Alterations
28 Ferring Street Ferring

Thank you for your internet representation made on 10th December 2012 which has been recorded as '**an objection**' with the comments as follows:

DRW NO 6b SCALE 1/50 (A3)
PROPOSED FRONT ELEVATION

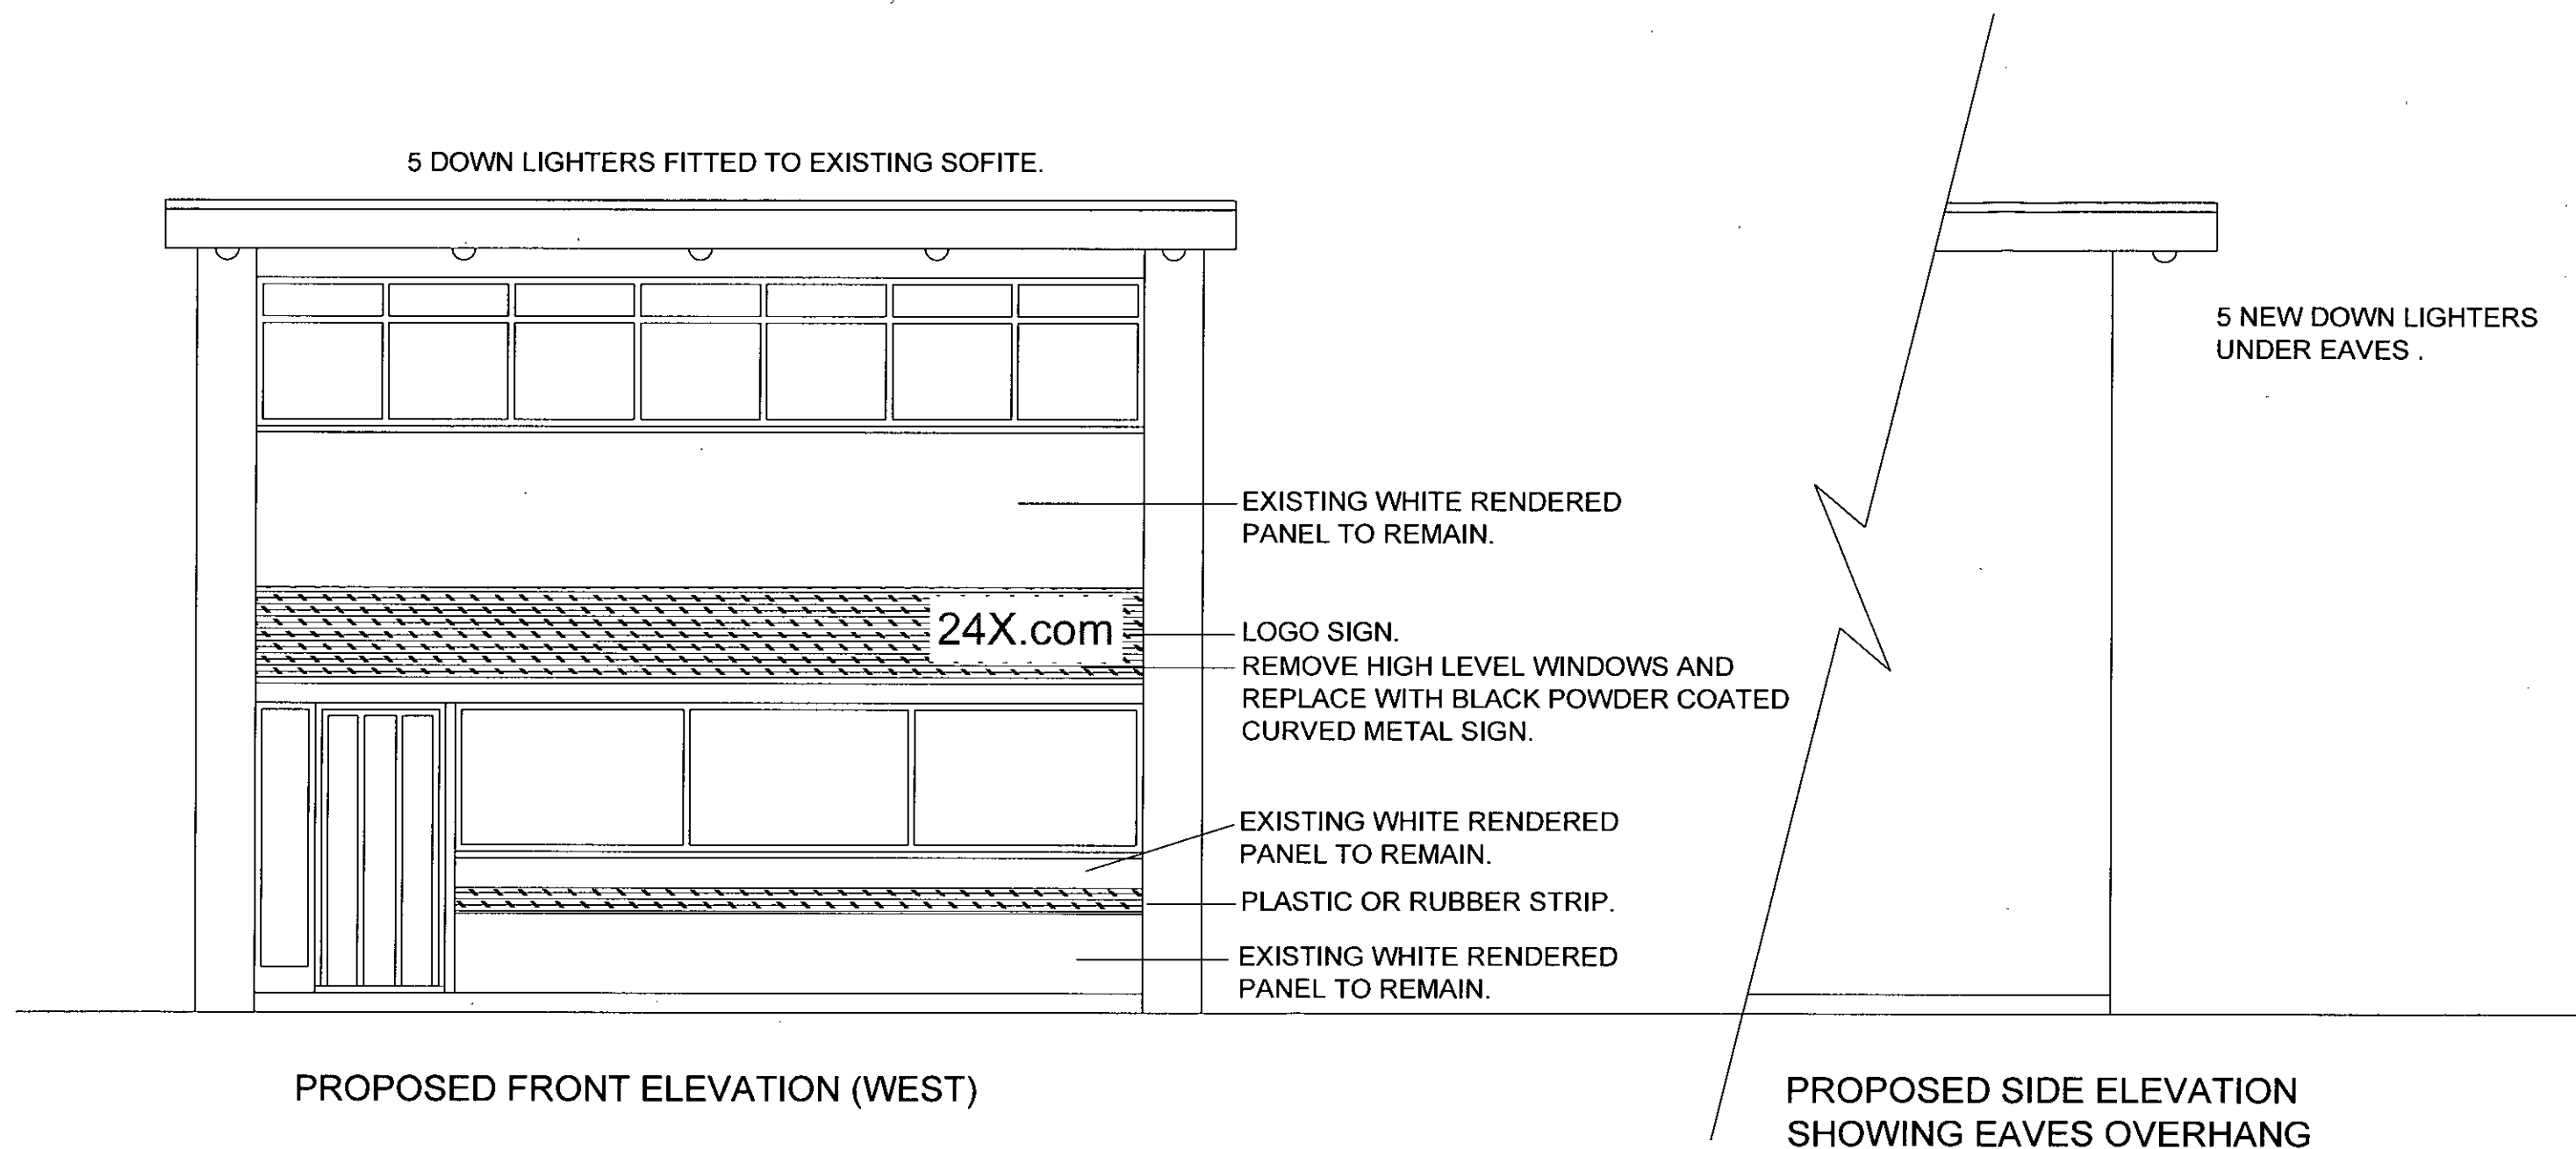
Ferring Conservation Group objects to this application on the grounds that its proposals for fascia and lighting do not acknowledge that the premises are immediately adjacent to the very small Ferring Conservation Area.

It is not possible to judge from the diagram of the west elevation what the fascia will look like or where the lighting will be placed. Nor is there any indication as to what times the illumination is intended to operate. 'Brushed alloy' may possibly be appropriate but it may be rather garish and 'in your face'. We would want to see the fascia and its illumination to be discreet and in keeping with the character of the Conservation Area (and, indeed with the character of an Undertaker's premises.
